HGN19678 – Charville Lane Estate Street Work Appeal

Address LAND AT CHARVILLE LANE ESTATE CHARVILLE LANE HAYES

Development: Installation of an 18 metre high, monopole tower, associated radio-equipment cabinets including one that will wrap around the base of the mast, and ancillary development hitherto (Application under Class A, Part 16 of Schedule 2 to the Town and Country Planning (General Permitted Development) (England) Order 2015 (as amended) for determination as to whether prior approval is required for siting and appearance).

LBH Ref Nos: **76859/APP/2021/4183**

Title:
215 PROPOSED SITE PLAN

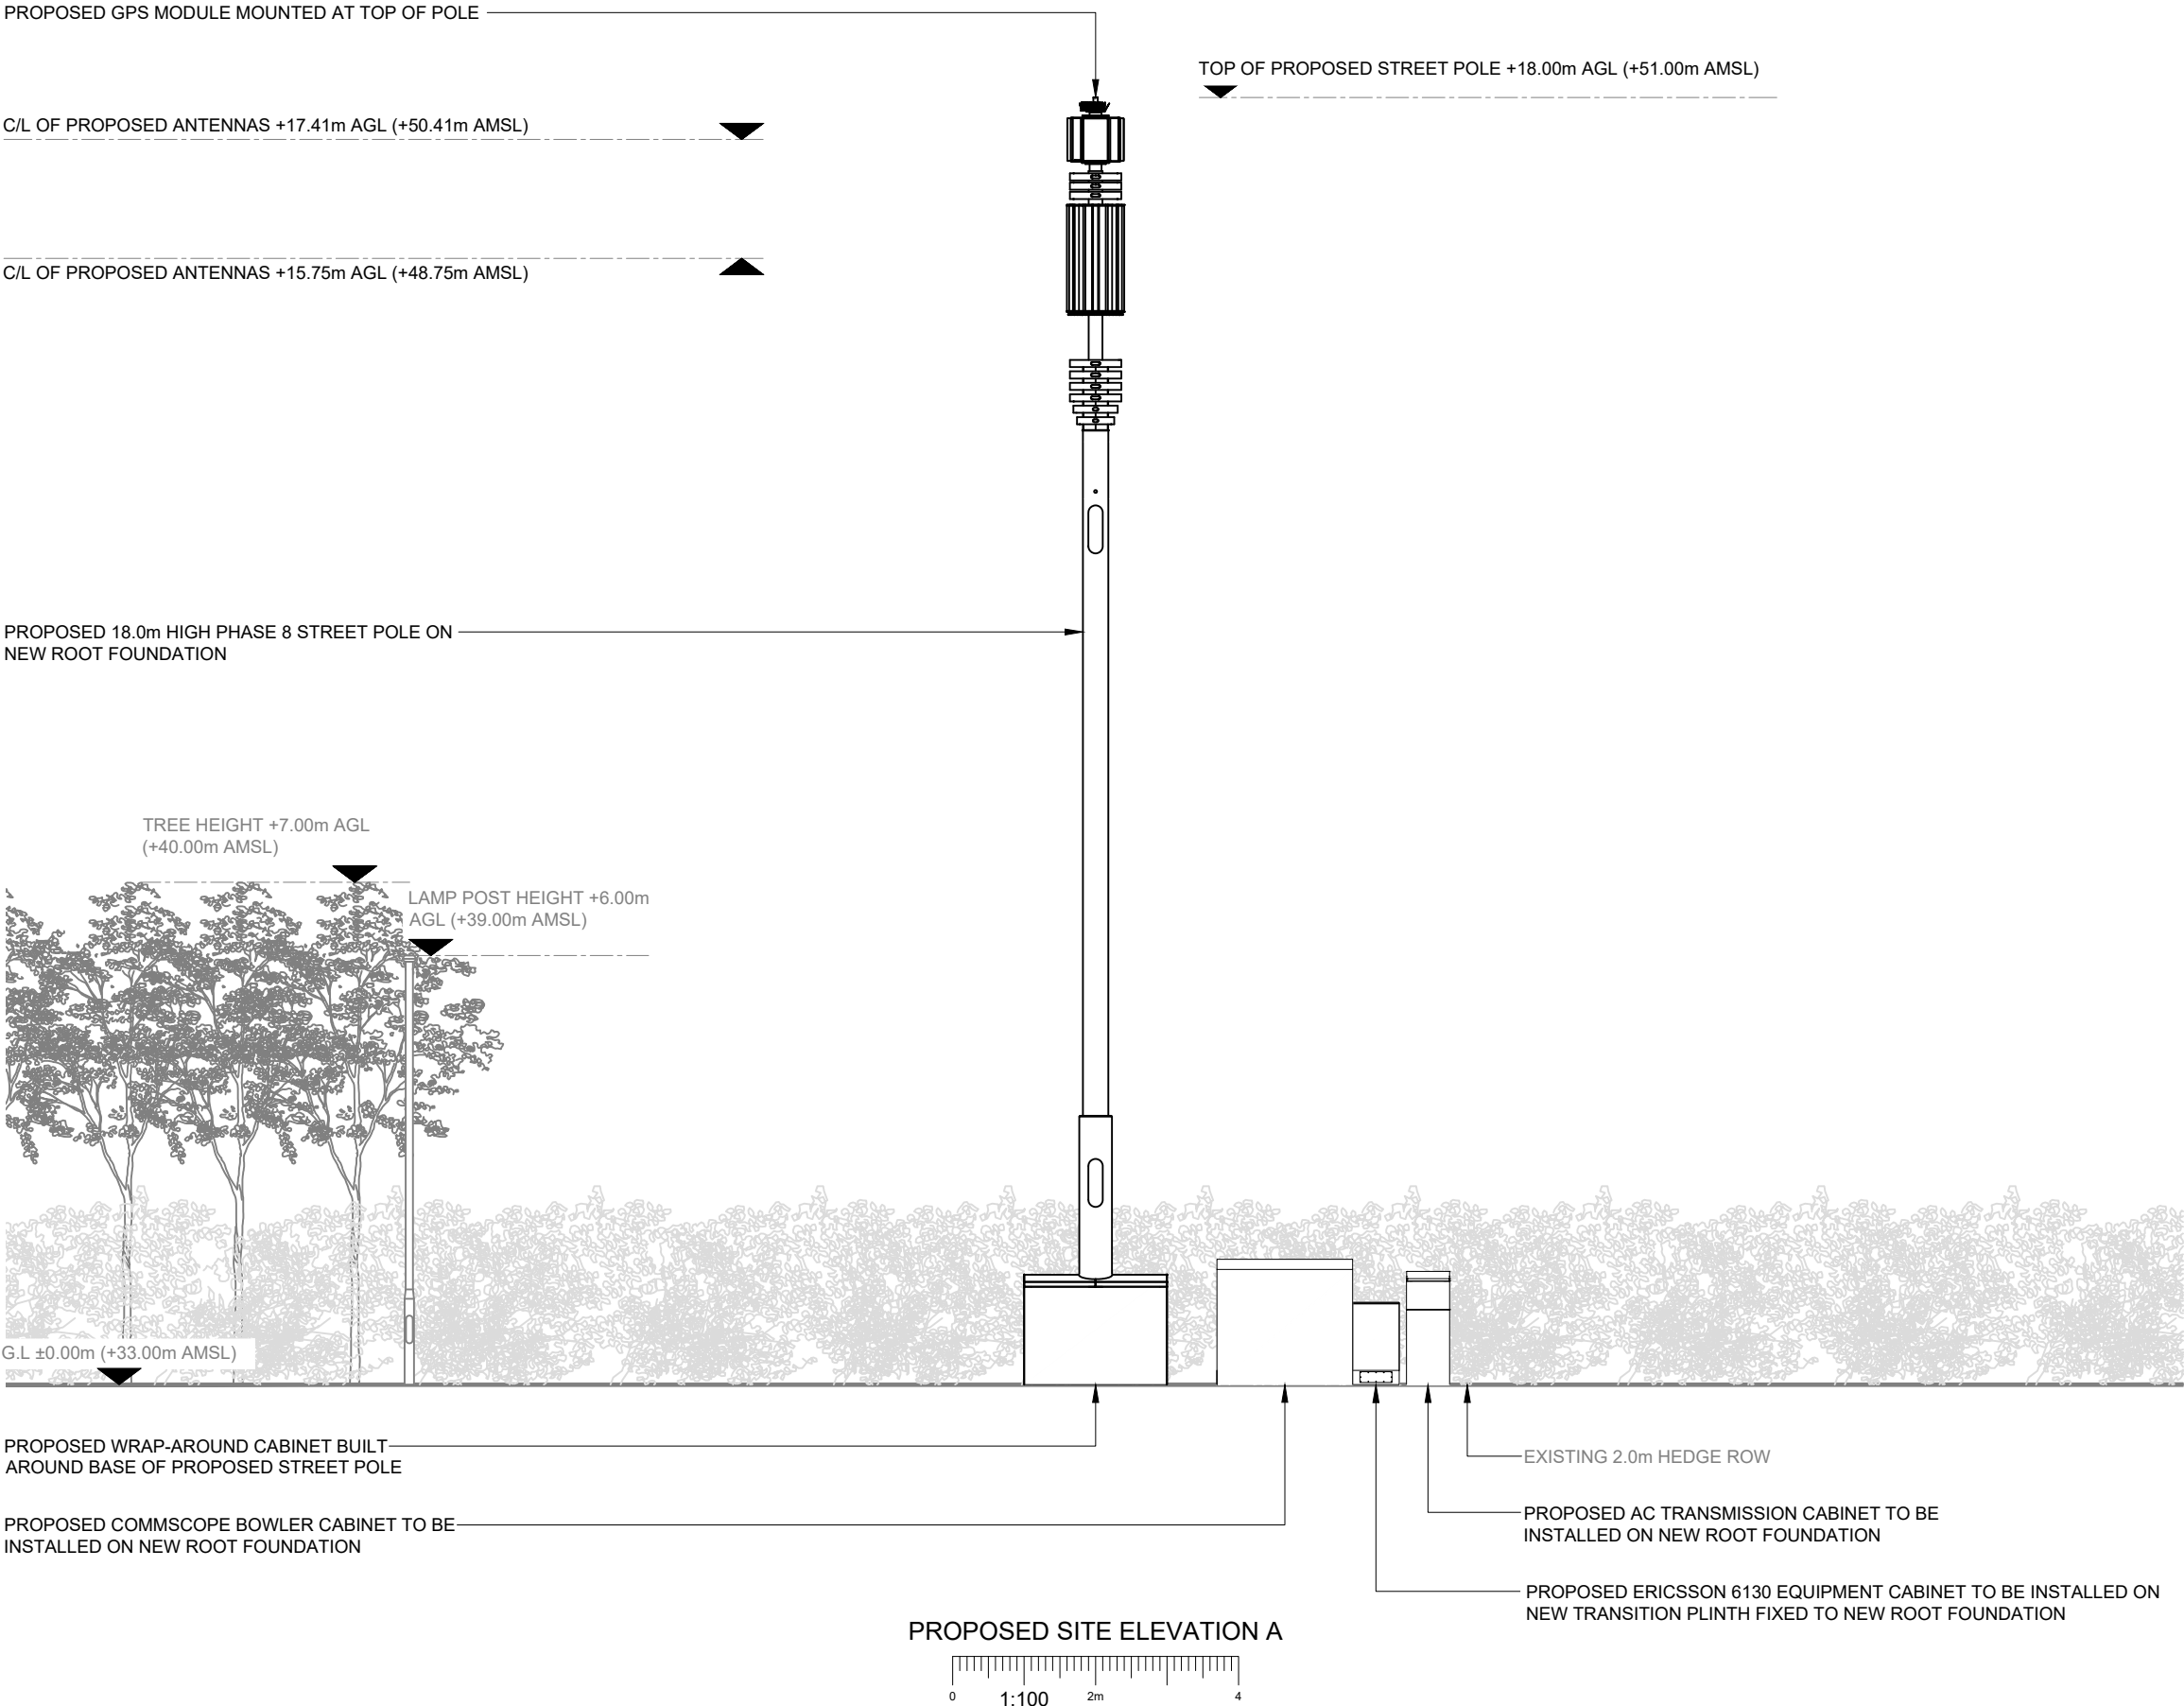
As mentioned in the site description section, the subject parcel of land is occupied by a wide grass verge located on the south side of Charville Lane, opposite the junction with Hoppner Road and the Charville Lane Housing Estate. The grass verge is backed by a hedgerow and some trees set within an open, spacious and green setting. While there is residential development to the north of the site, these are set back from the application site with wide grass verges, including some planted with wildflowers. Overall, the area is spacious, open and verdant which is characteristic of this setting and the designated Green Belt.

Due to the spaciousness of the setting, and the location of the site adjacent a junction, the proposed monopole would be clearly visible from multiple vantage points and for a significant distance. This would clearly have a greater impact on the open character of the Green Belt than the existing non-developed land, contrary to policy DMEI 4 of the Local Plan. At ground level the expanse and scale of the proposed cabinets would appear cluttered and harmful to the green belt setting.

It would introduce, by reason of its prominent siting and massing a significant clutter and mess to the streetscene which would not be hidden or blended into the existing landscaping. The proposed street pole would be readily visible from various public vantage points, including from nearby residential properties and where it would appear as an incongruous and visually obtrusive form of development. Furthermore, long views of the proposed street pole would be available by various road users on Charville Lane and also Hoppner Road. It is therefore considered that the siting and appearance of the proposed street pole would have a detrimental impact on the character and appearance of the area.

Drawing No:	HGN19678_HGN302_84876_UB0925_GA_REV_C	Issue:	(
-------------	---------------------------------------	--------	---

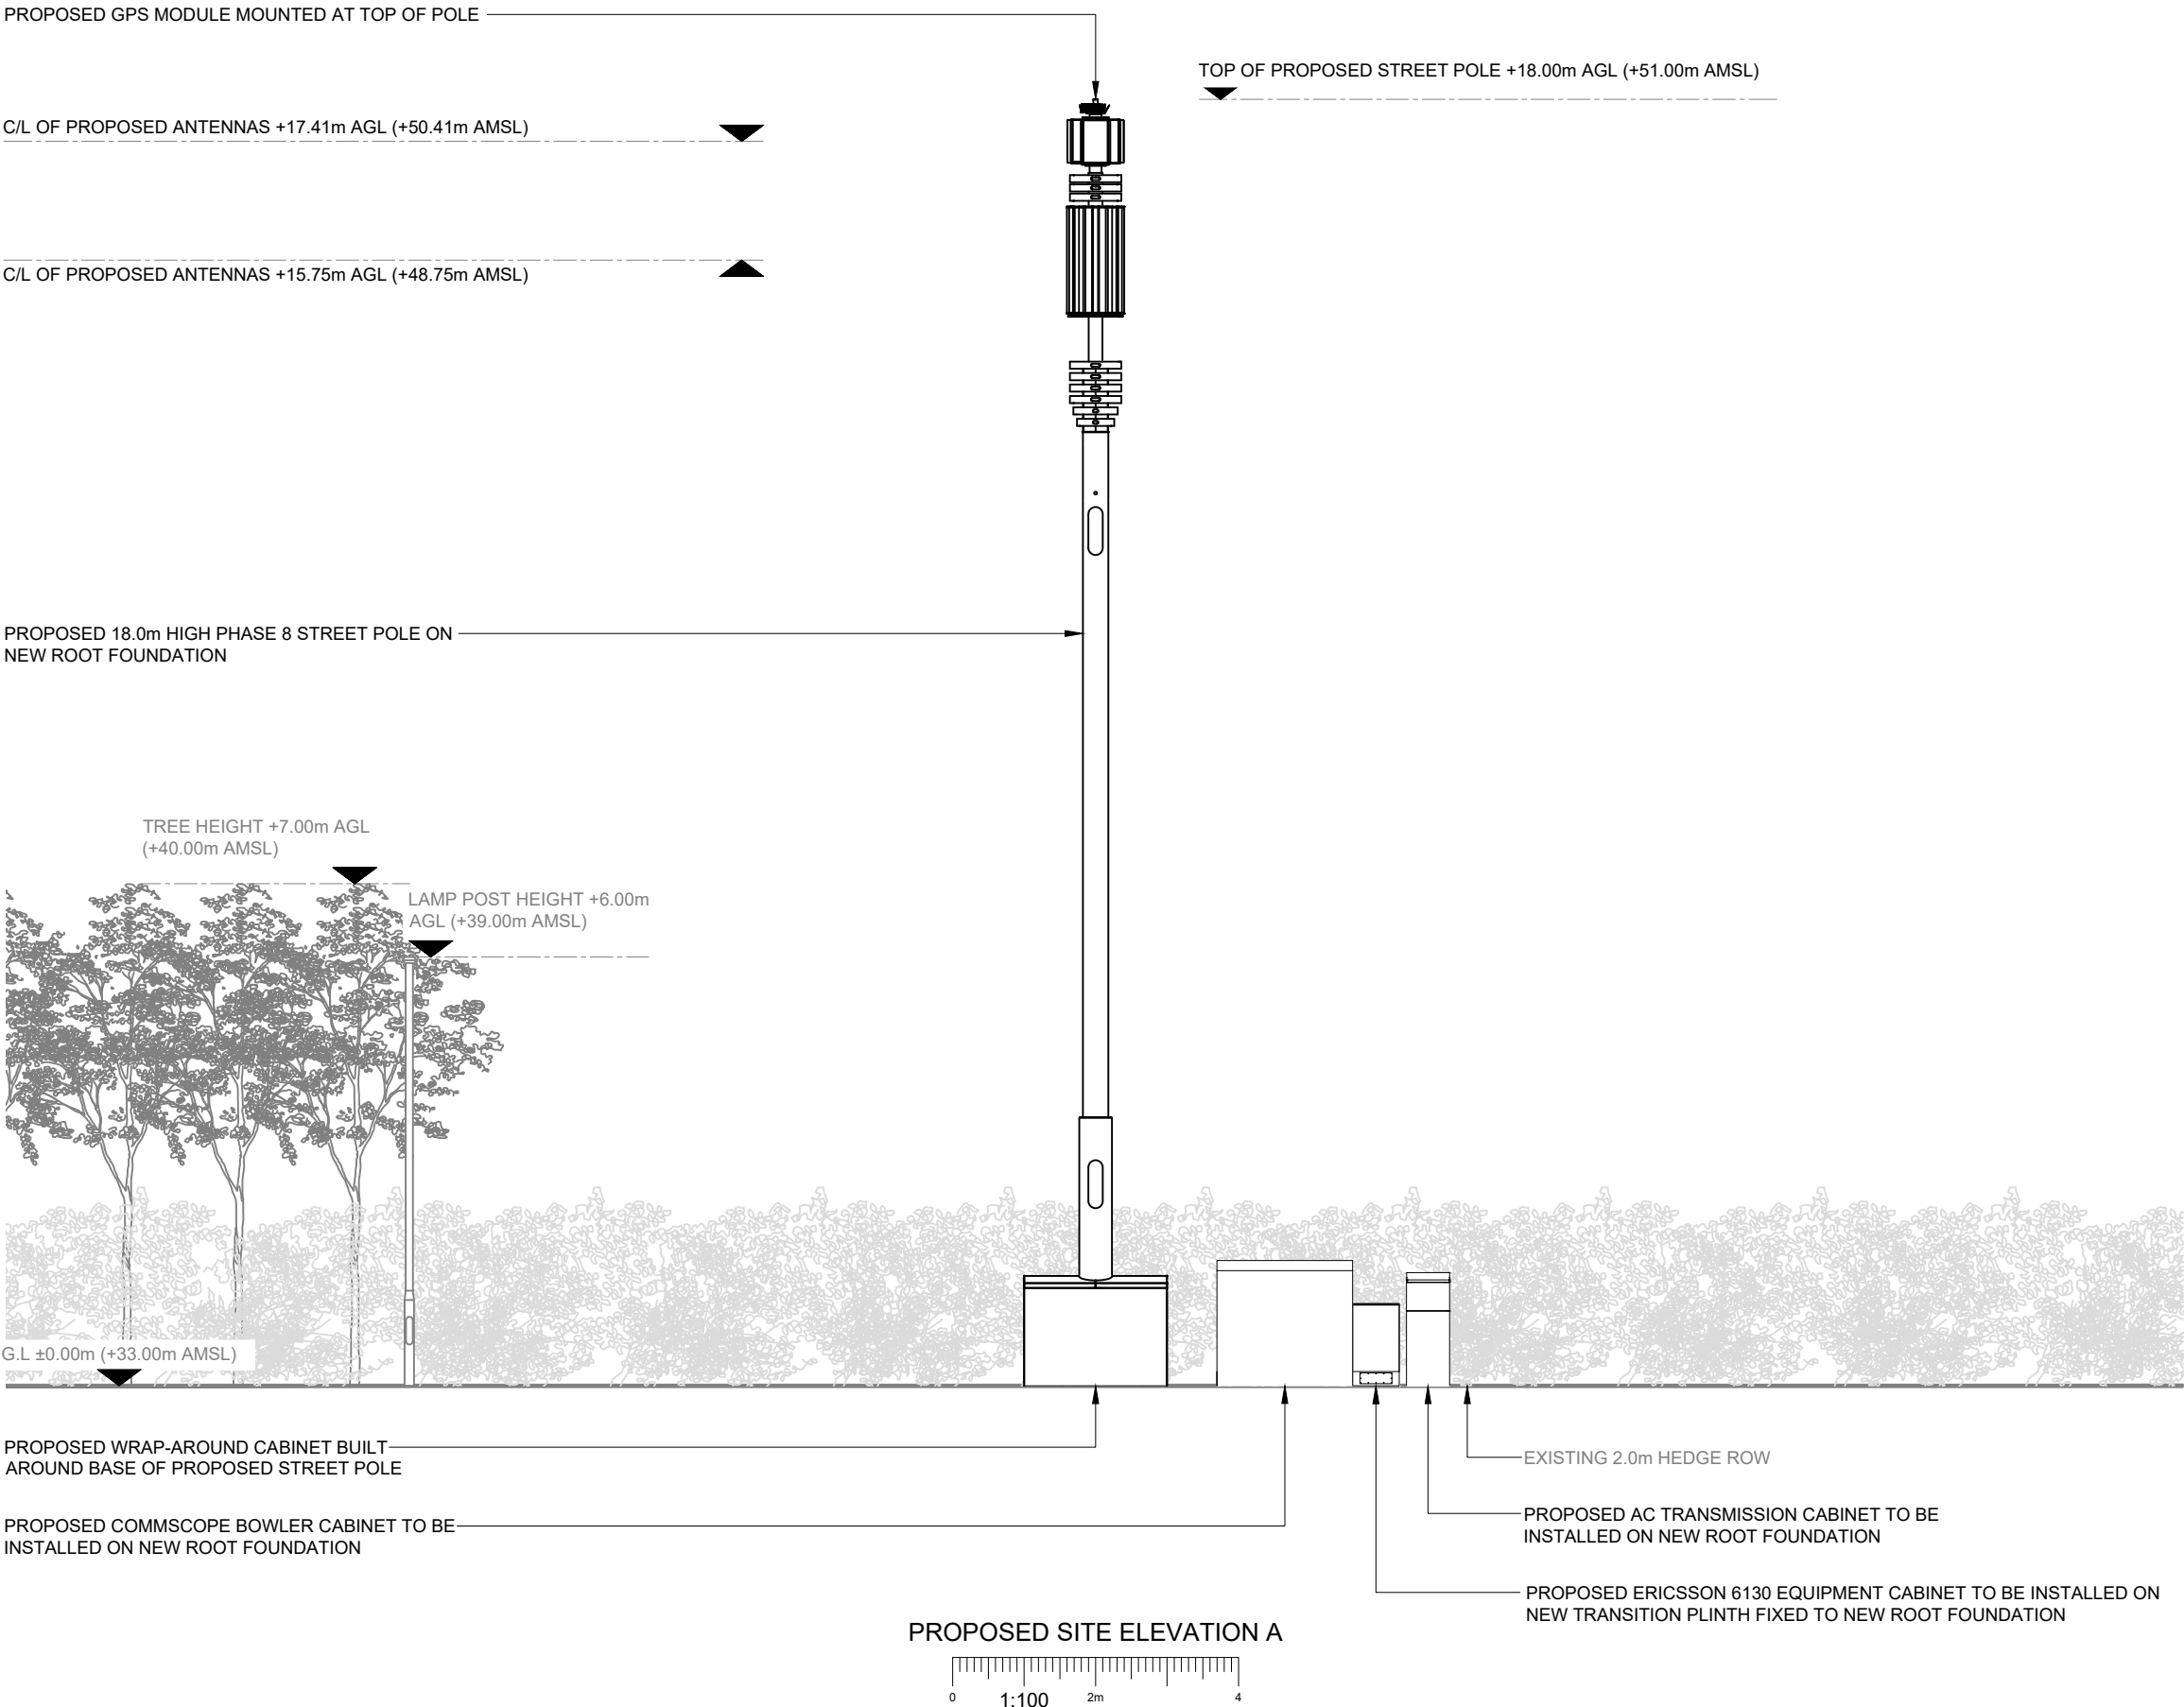
With a height of 18 metres, the proposed monopole would be significantly taller than the current street furniture (including 6m high street light poles) which are small in scale, spaced out and blend into the wider setting. There would also be 4 cabinets at ground level, including one that wraps around the proposed monopole.

The base of the monopole would be approx. 2m metres wide and 1.3m deep, and its top apparatus would have a diameter of approx. 0.6 metres. This again, would be considerably greater than the nearby lampost poles. This would be a significantly bulky and dominating addition within the subject parcel of land.

The site is within a very prominent location to which the proposed monopole, by reason of its general siting (as proposed), combined height, width and depth alongside its scale,

bulk and overall design would result in an imposing, dominating, incongruous, overbearing and visually intrusive addition that would negatively impact the character and appearance of the area.

In terms of the materials, it is proposed to have a steel colour grey finish to replicate similar lamp posts of the context. The cabinets would be finished in a green colour. The materials and colours to be similar of nearby street furniture (which are smaller) would not mitigate the impact the proposal would have to the character and appearance of the surrounding area, in terms of its height, scale, siting, size and bulk.

The proposal also involves the installation cabinets of various sizes. Cumulatively, the proposed cabinets, in conjunction with the proposed street pole would result in cluttered street paraphernalia which would be detrimental to the character and appearance of the area.
